Our ref: DOC19/448306-1
Your ref: DA 80/952 MOD 4
File: SF19/48078

Glendell Mine (DA 80/952) Modification 4 – Response to Submissions report and Draft Conditions of Consent

Glendell Mine Modification 4 – Response to Submissions Report and draft conditions of consent

Offset Strategy Plan

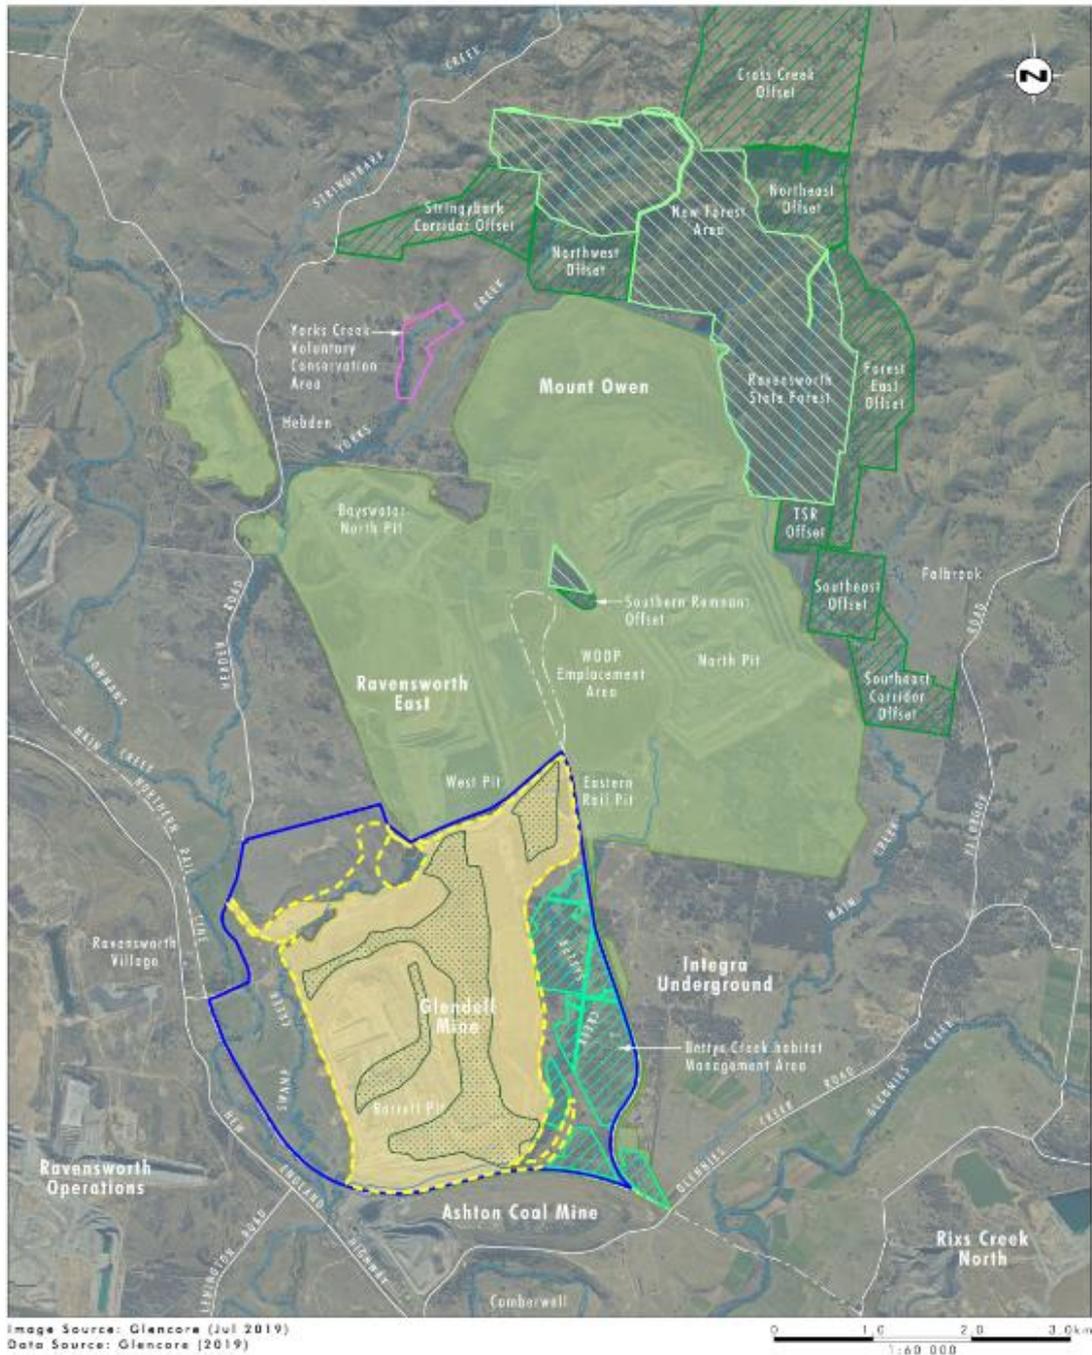
7. The Southern Remnant and Southern Remnant Offset need to be added to the Offset Strategy Plan map in Appendix 5

The map of the 'Offset Strategy Plan' presented in Appendix 5 of the Glendell Mine consolidated consent includes most, but not all of the biodiversity offsets in the adjacent Mount Owen Mine site. The map does not show the Southern Remnant or the Southern Remnant Offset of the Mount Owen Mine complex. BCD recommends that the Southern Remnant and the Southern Remnant Offset are shown on a revised version of the Offset Strategy Plan in any new consent issued to complete the map.

Recommendation 7

BCD recommends that the 'Offset Strategy Plan' in Appendix 5 of any updated version of the Glendell Mine consolidated consent includes the Southern Remnant and the Southern Remnant Offset.
